**KIRKLEES METROPOLITAN COUNCIL
INVESTMENT & REGENERATION SERVICE**

**DELEGATED DECISION TO DETERMINE PLANNING APPLICATION FOR
ADVERTISEMENT CONSENT**

Reference No: 2019/64/93525/W

Site Address: 8, Morley Lane, Milnsbridge, Huddersfield, HD3 4NZ

Advertising Billboard Application. March 2020

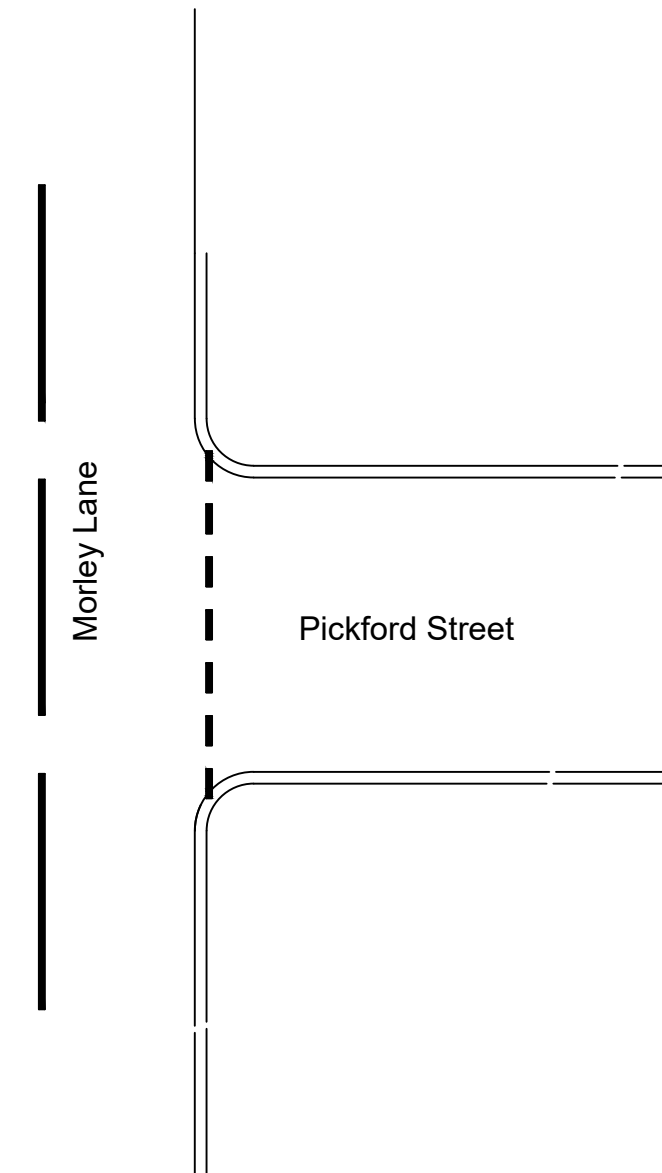
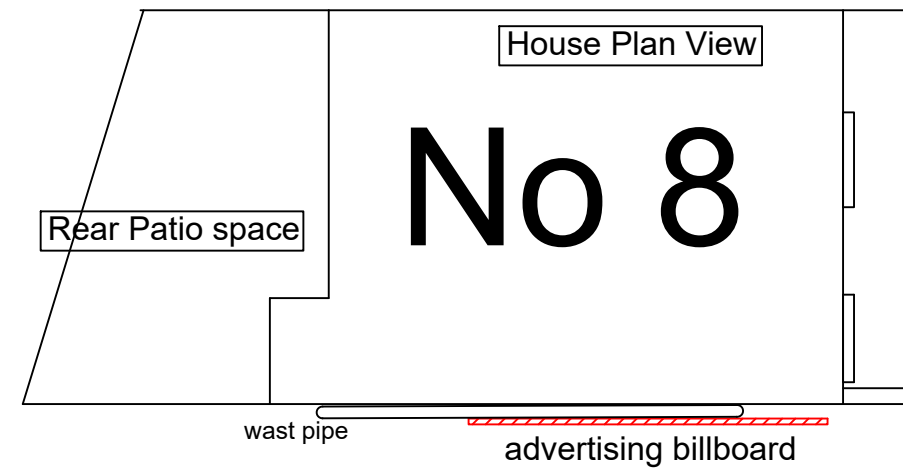
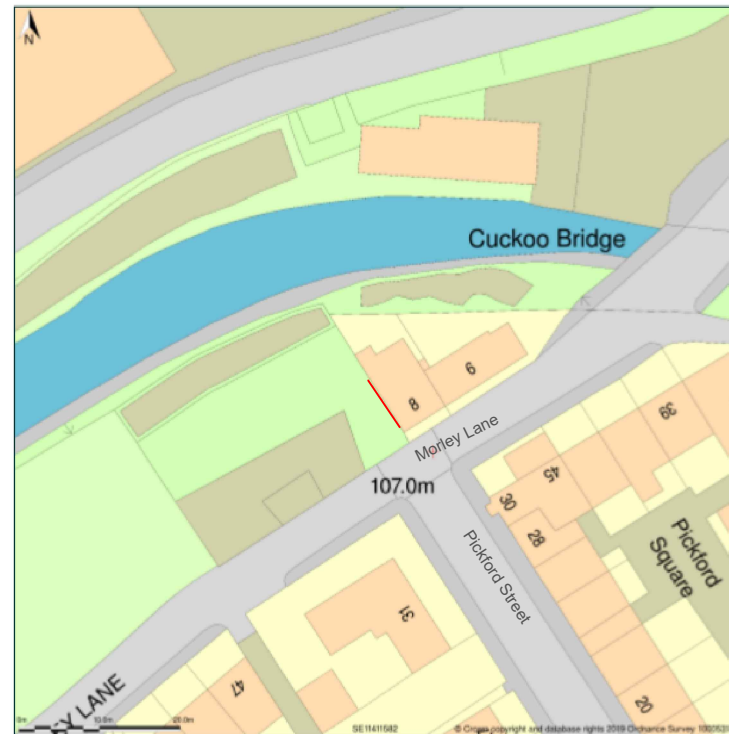
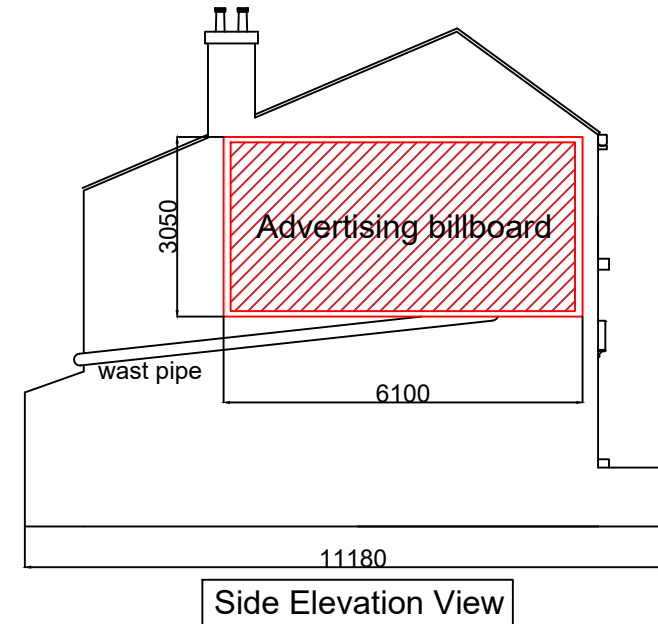
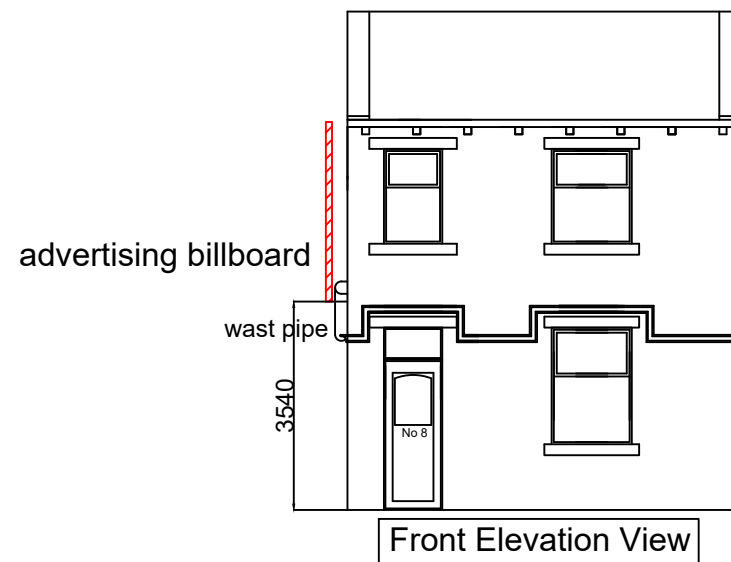
Notwithstanding the above, it is considered that in this location commercial advertising, especially a billboard of the scale shown and in a prominent position on a building overwhelming the gable elevation of the building, would introduce an alien and intrusive feature to the street-scene that would be out of character with its surroundings and would be harmful to visual amenity.

1. The proposed advertising hoarding would be affixed to a building of domestic scale and appearance and in a mainly residential setting. It is considered that commercial advertising in this location, and especially a hoarding of the scale and siting proposed, would introduce an alien and intrusive feature to the street-scene that would be out of character with its surroundings, out of scale to the adjacent domestic property and harmful to visual amenity, contrary to the aims of Policy LP25 of the Kirklees Local Plan and Paragraph 132 of the National Planning Policy Framework.
